Application No: P/165/21/PL  
Site Address: Land at Spinnaker View Pagham PO21 3FL  
Description of works: New vehicular access entrance, relocated parking bays, and pedestrian access associated with the redevelopment of the rear of Inglenook Hotel as 9 No. dwellings. This application is in CIL Zone 4 (zero rated) as other development. This application may affect the setting of a Grade II Listed Building.

Thank you for your internet representation made on 7th January 2022 which has been recorded as an objection with the comments as follows:

Drawing Title	Site Layout
---------------	-------------

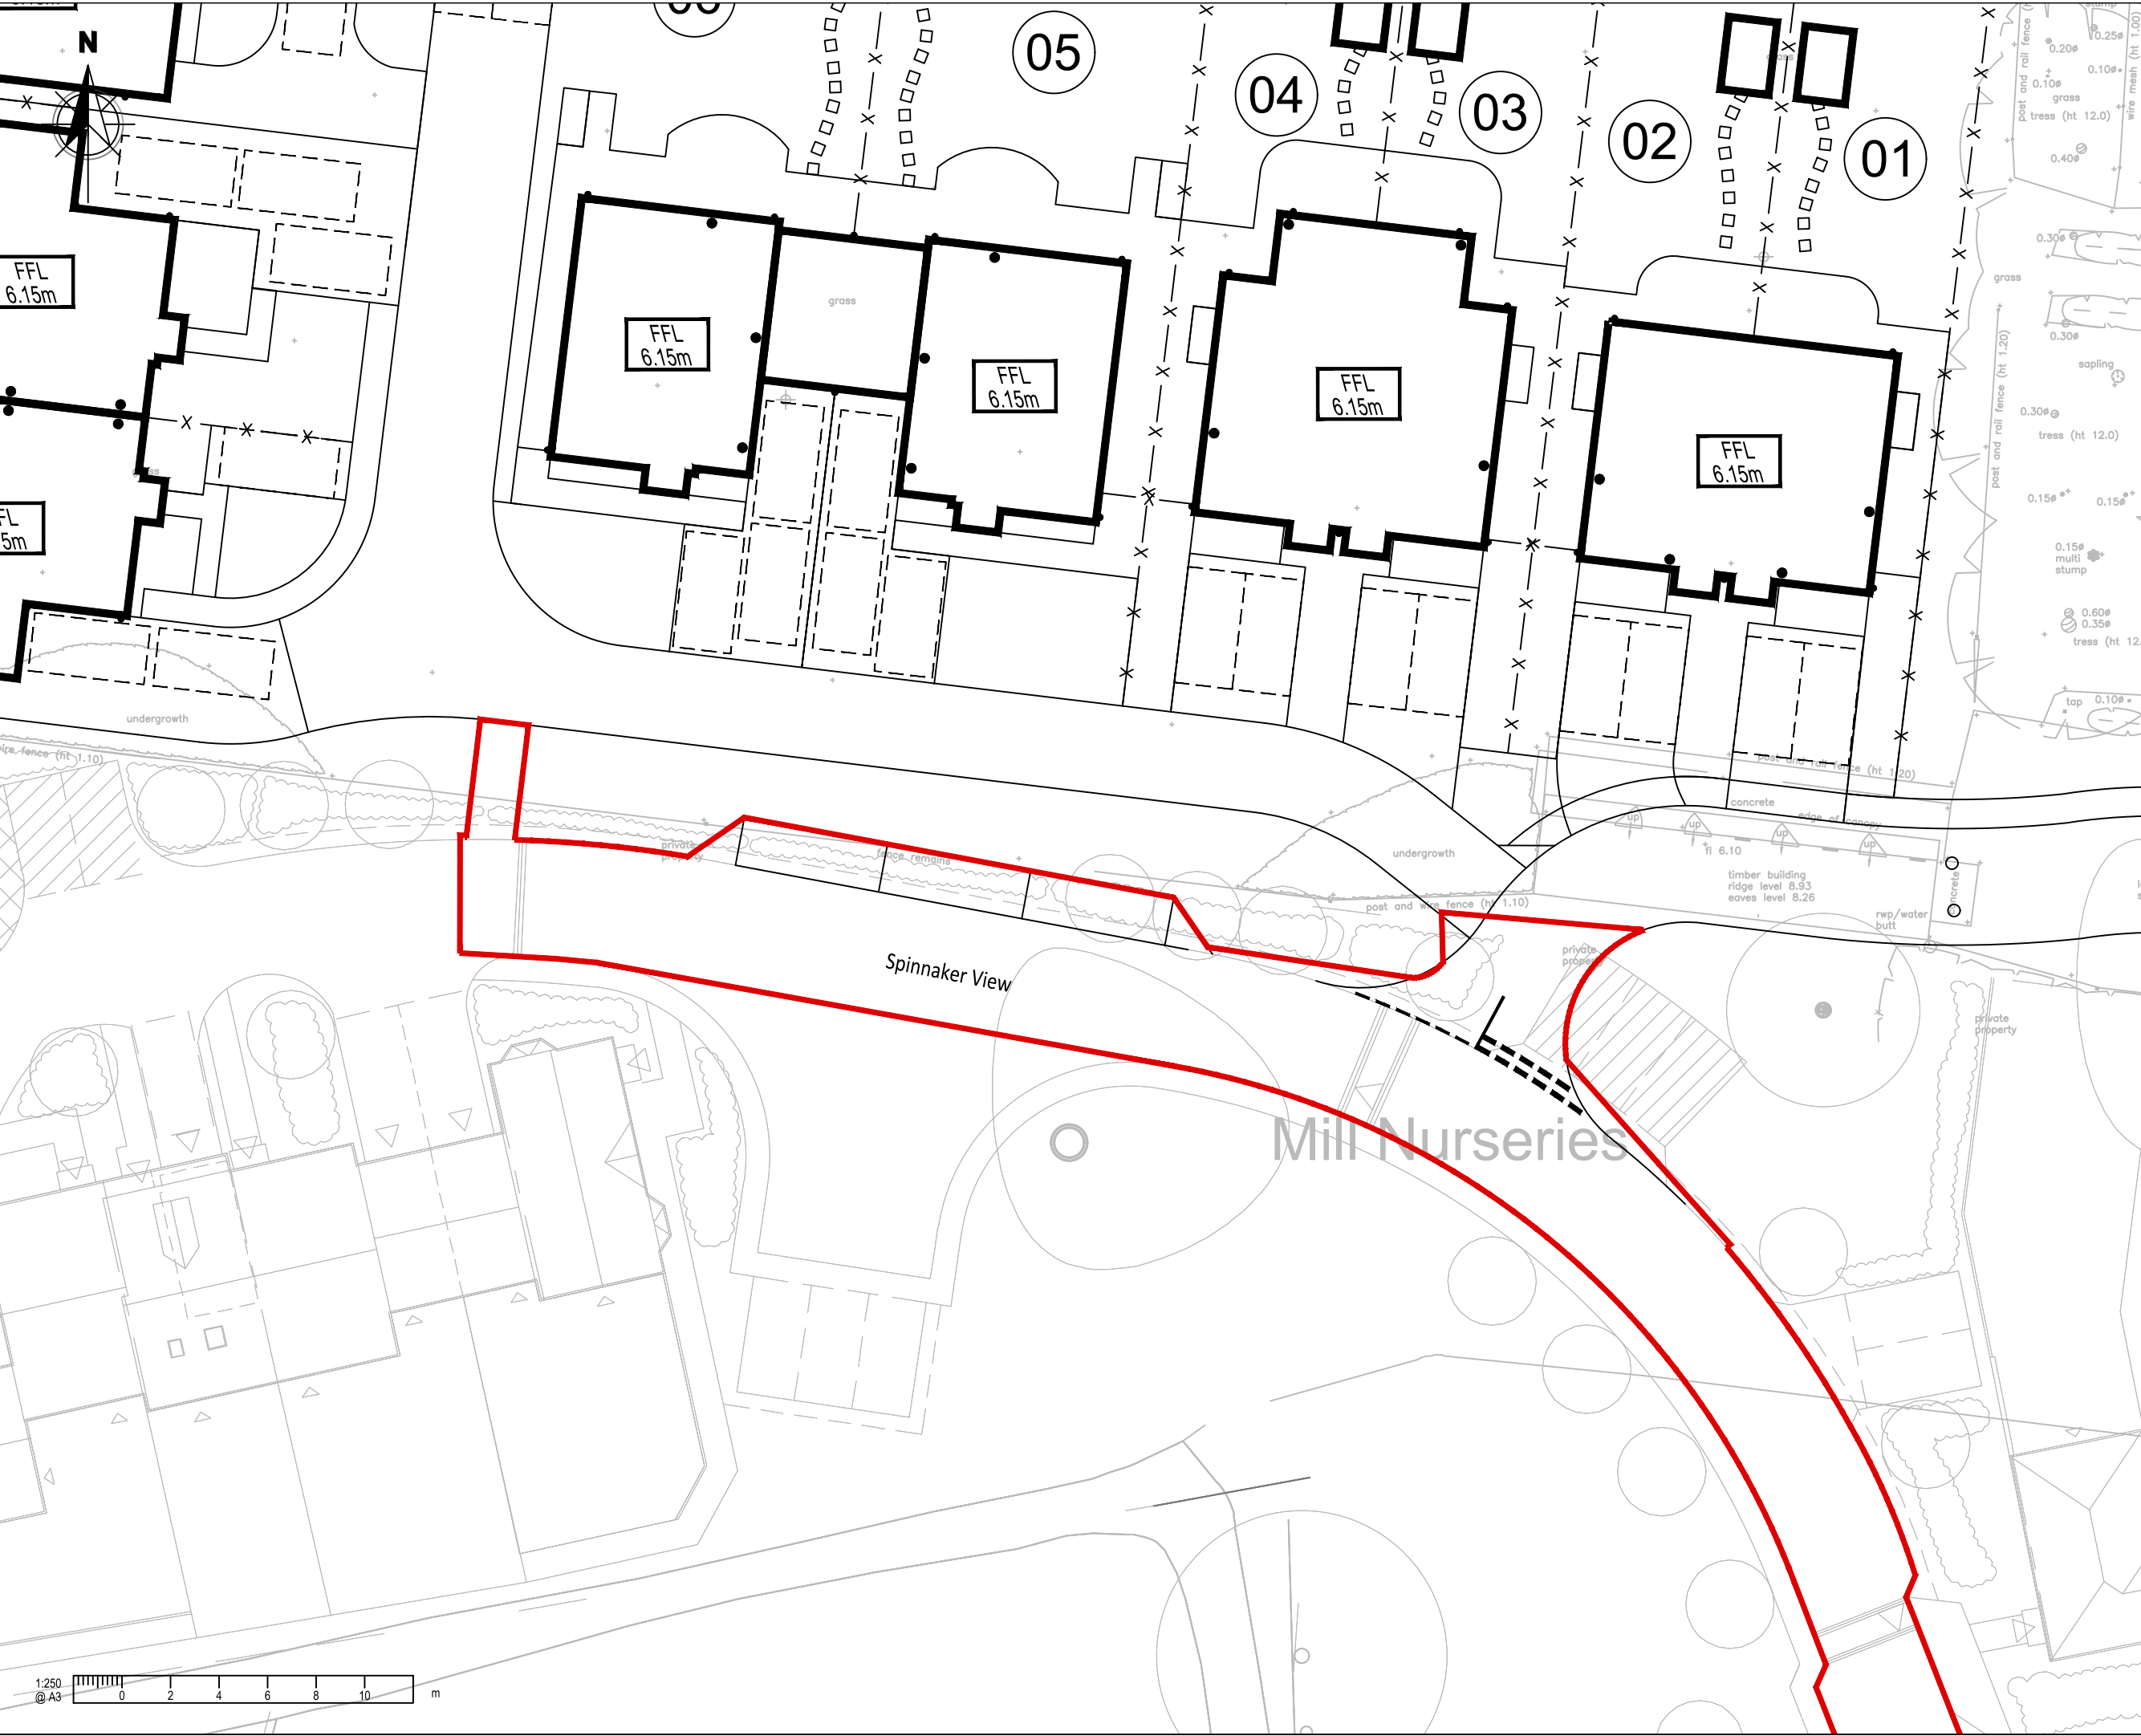
The reduction of our required turning circle will make it impossible for the refuse truck to turn round, this was a planning requirement for our site also using the footpaths as visitors parking will require residents walk in the road.

The Planning application also request a second entrance into Spinnaker view for bin storage the area can only accommodate 22 bins no more. it is impossible
